SUNNICA EAST AND WEST 500MW SOLAR ENERGY FARM

1.1 As an Interested Party, the Suffolk Preservation Society (SPS) wishes to make observations on the information regarding Landscape and Visual Impacts provided by Sunnica in response to the Secretary of State's letter of 1 December 2023.

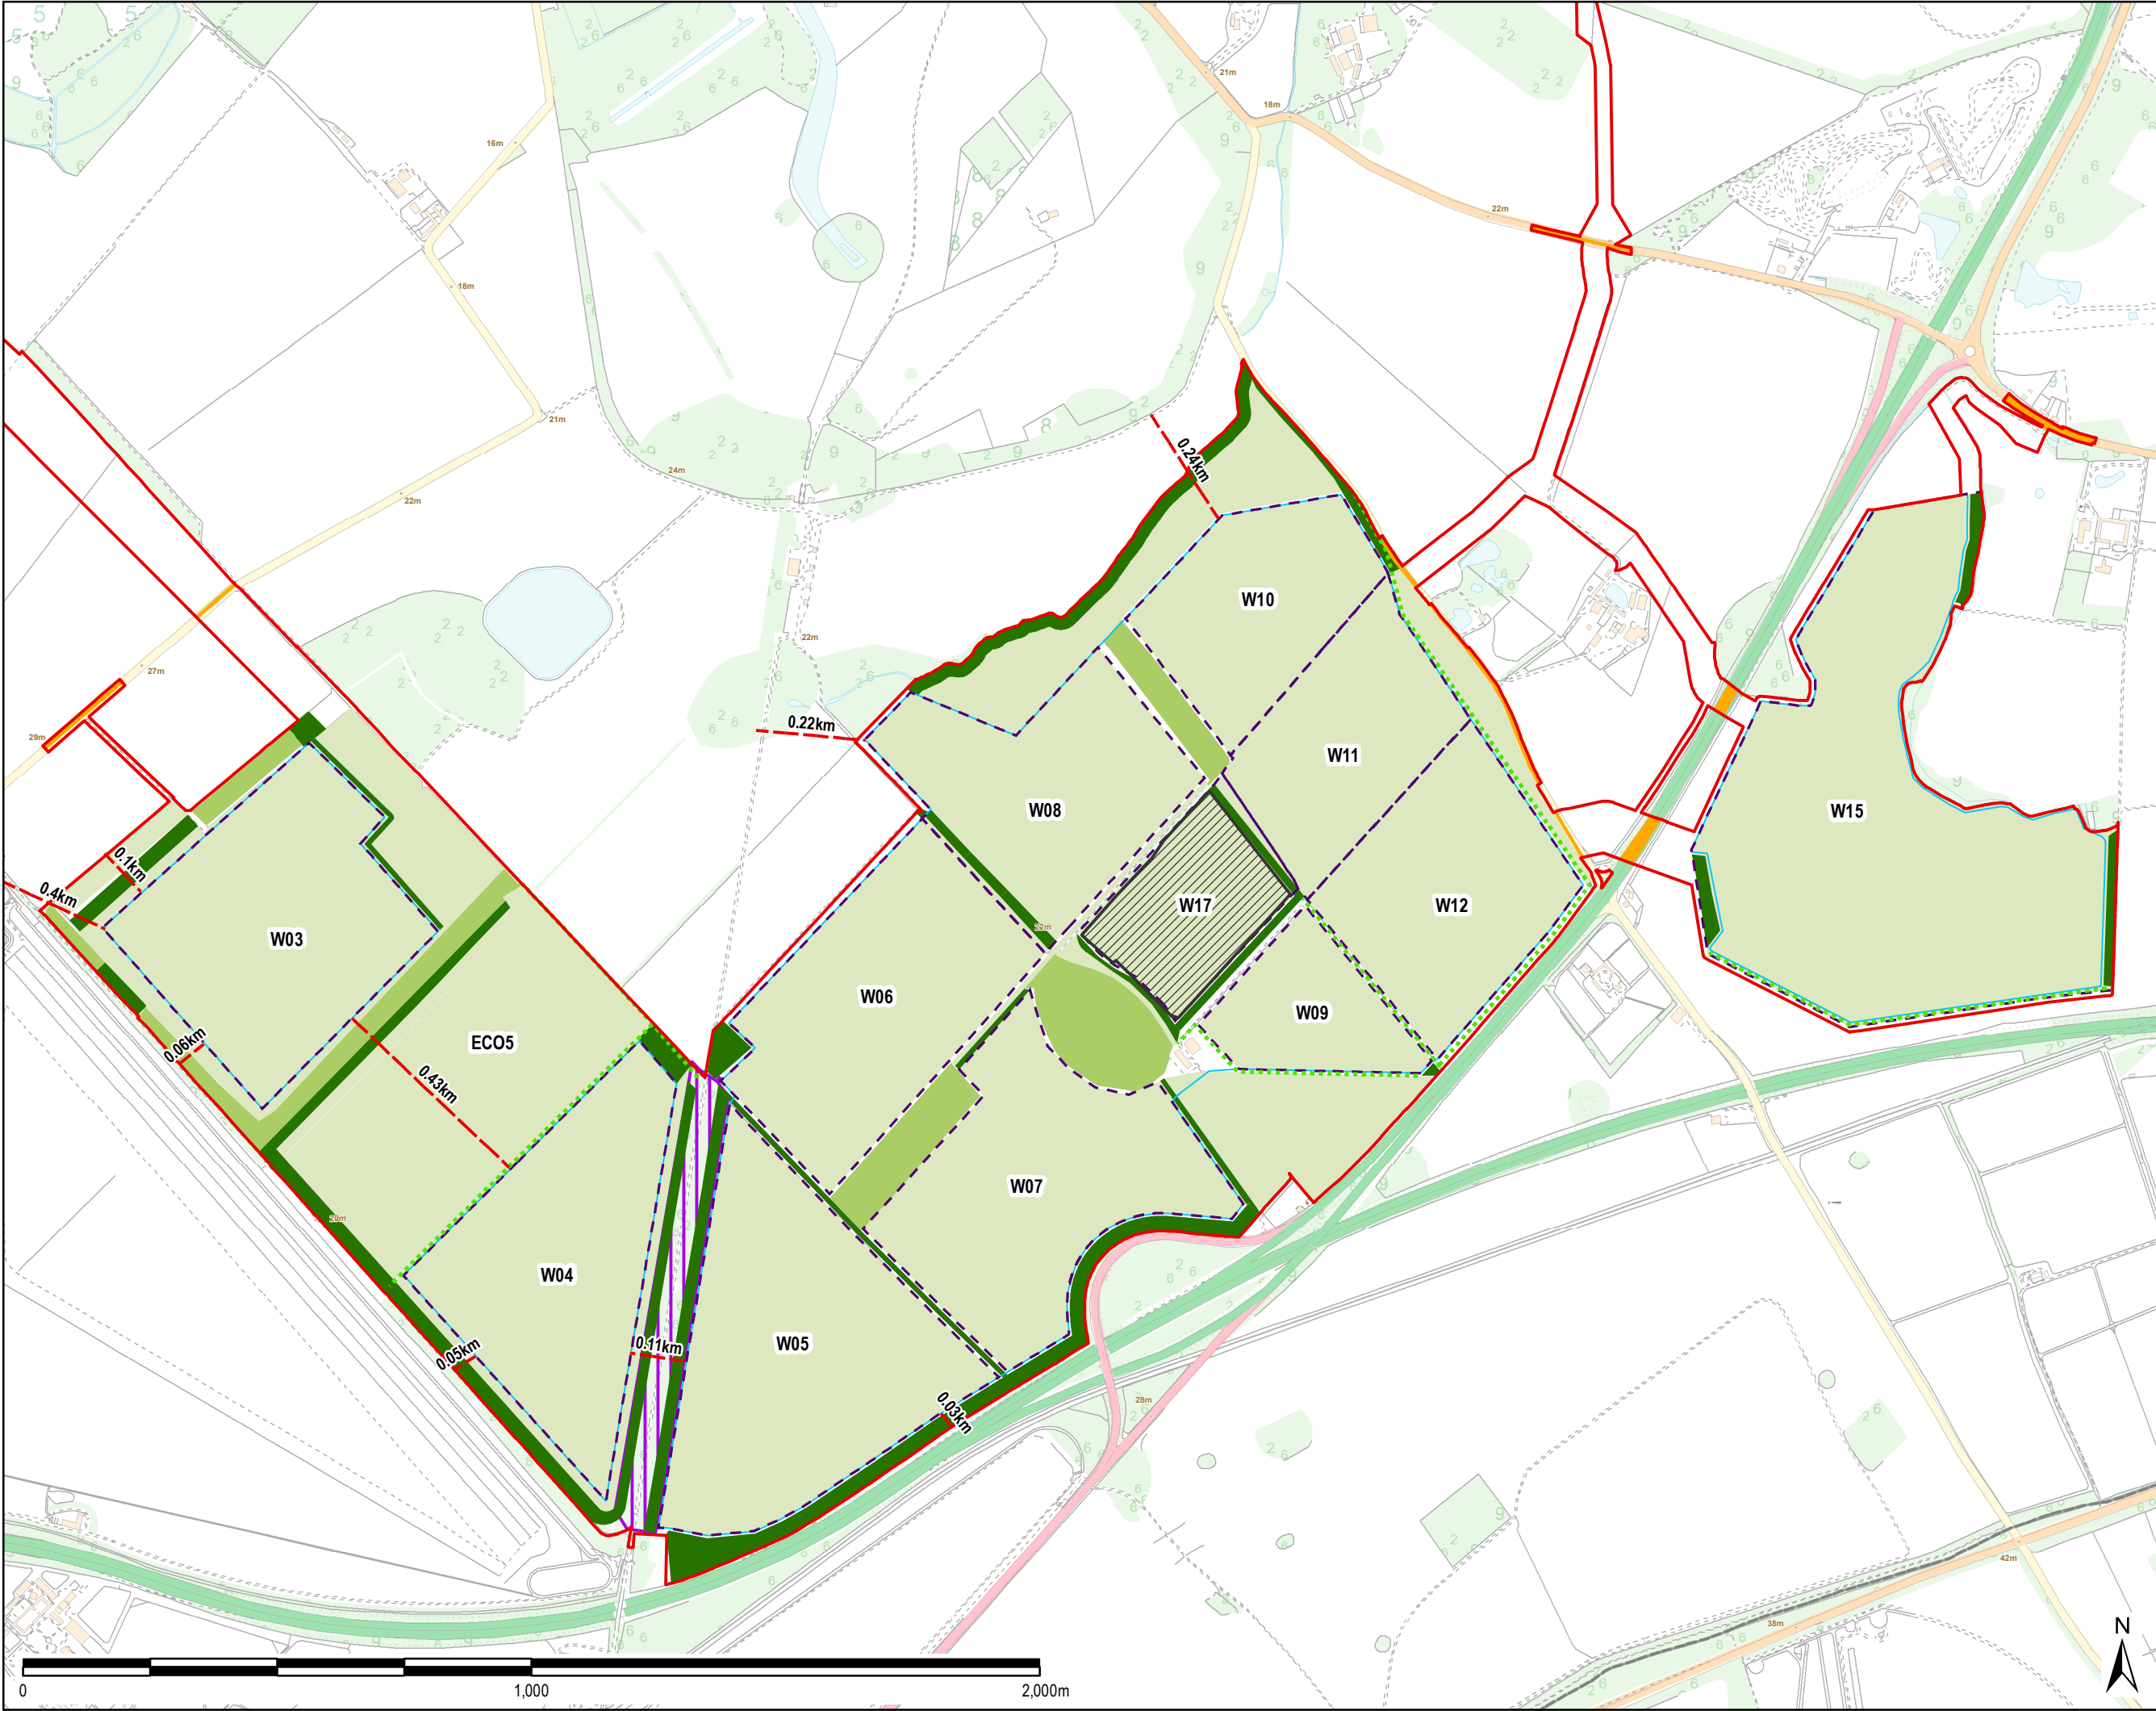
3.2.1 SPS considers that the LVIA submitted by the Applicant fundamentally underestimated the sensitivity of this landscape by assessing the Limekilns Gallops as being of medium value which gives insufficient weight to the rarity or cultural value of the Limekilns.

3.2.2 In response to the Secretary of State's request, the Applicant has set out its position regarding the mitigation of the harmful visual landscape impacts from the Limekilns Gallops. The elevated topography of the Limekilns which extends to above 50m (AOD), whilst the land within site parcels W05 and W07 is approximately 25m AOD, means that mitigation planting will be ineffective in screening the development. The Applicant has considered and rejected the introduction of screening bunds up to 4 metres in height to screen the West Site A site area from views from the Limekilns, concluding that an earthwork bund at this height would be incongruous in the predominantly flat landscape. It would also introduce other effects including increased construction traffic and carbon emissions. Overall, it was concluded that the small improvement in visual mitigation would be outweighed by the additional adverse environmental effects and the reduction in the area available for renewable energy generation. The Applicant has therefore concluded that no further measures will be provided to mitigate the visual impacts. .

3.2.3 SPS therefore supports the local authority's call for the removal of West Site A from the scheme to mitigate this harmful impact. We disagree with the Applicant's position that the removal of the parcels would not result in a very significant landscape or visual benefit and we consider that this position demonstrates that the Applicant fundamentally underestimates the importance of this viewpoint.
